From: Simon Davis
Sent: 02 December 2019 16:16
To: James Hutchison [REDACTED]
Subject: RE: BR/233/19/PL - 77 Aldwick Road

REAR
PROPOSED ELEVATIONS
Scale 1:100

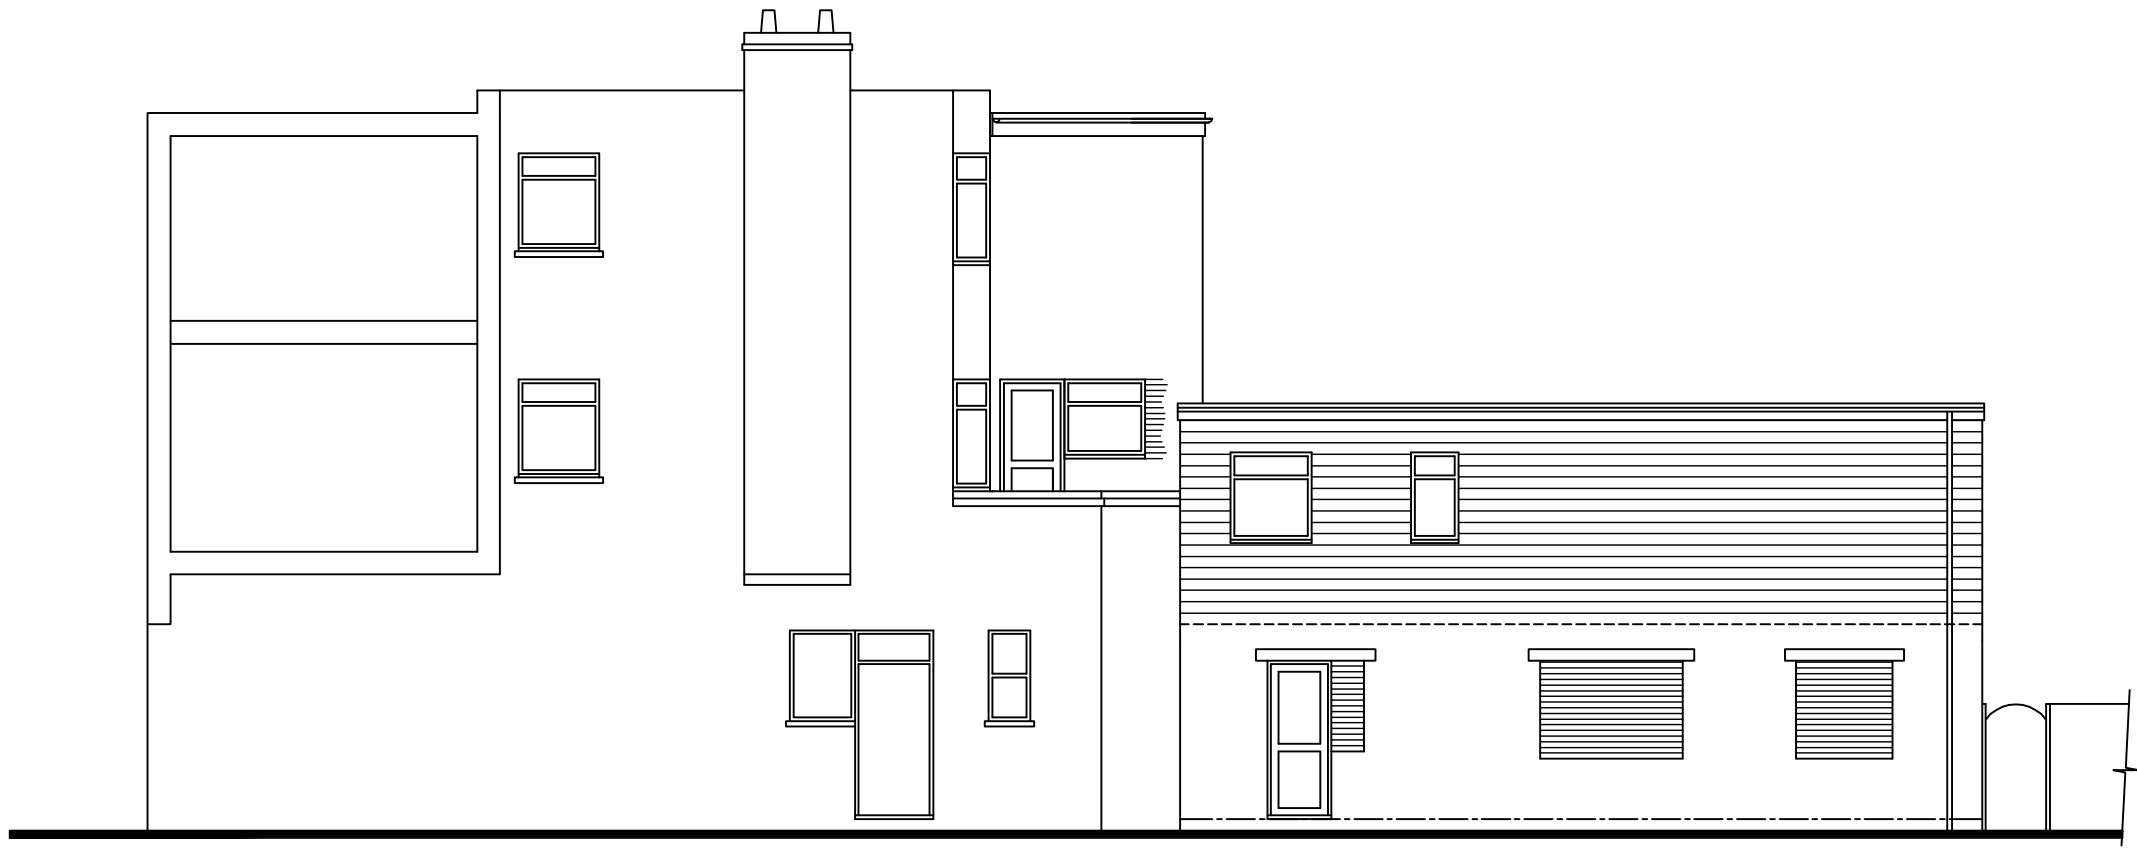
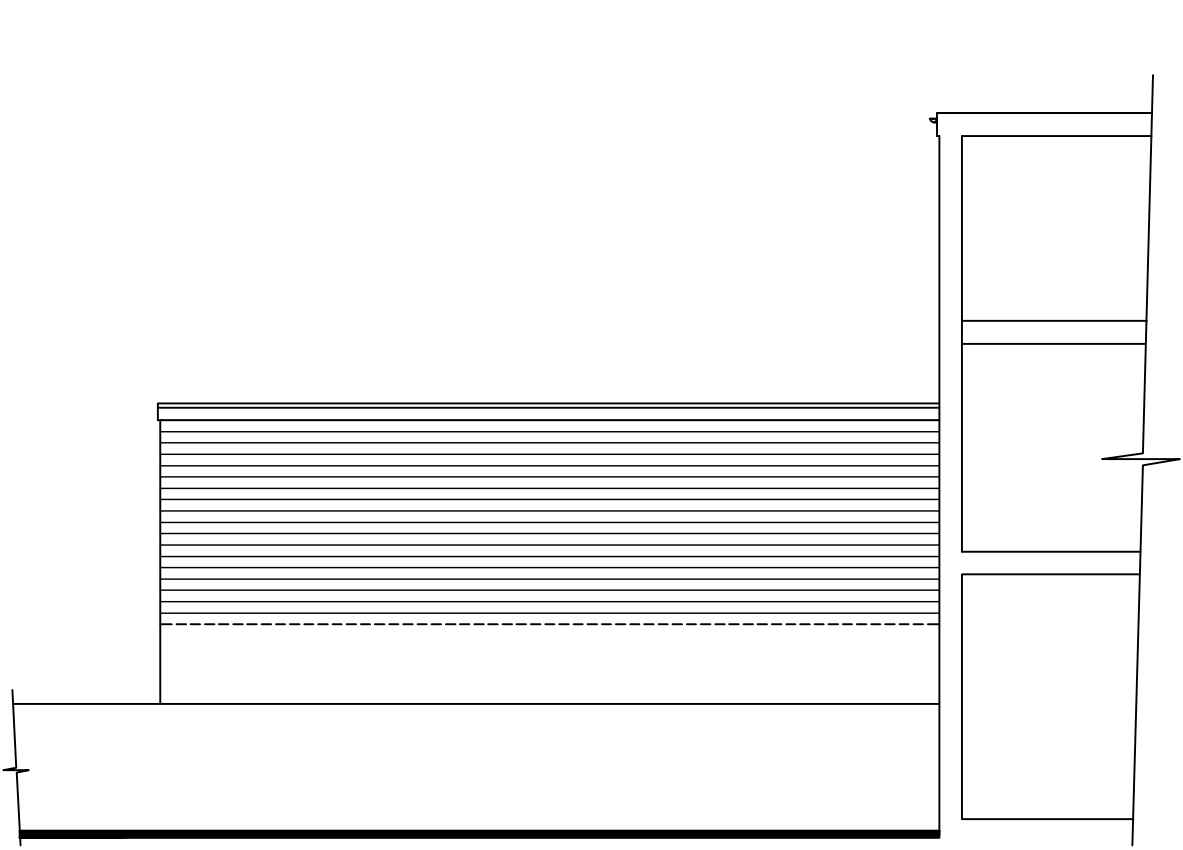
The relevant windows would be (1) the existing first floor flat's living/dining room window and the terrace/balcony which it shares with its kitchen; (2) the rear/rear side windows and terrace/balcony of the first floor flat on 79 next door and (3) the rear windows of the first floor on 77 next door.

I have discussed the application with my Team Leader and consider that we will refuse the application on grounds of residential amenity impacts to the existing flats on the building and the next door buildings. The reduction in the scale of the building from last time has improved the potential situation but we consider that there would still be impacts in terms of light loss/loss of outlook which cannot be resolved. You may have noted the local opposition (objections received) to the loss of the existing ancillary space to the dry cleaners. However, we do not have any policies which could be used to defend a refusal on those grounds. Your client may therefore wish to submit an application solely for the ground floor flat.
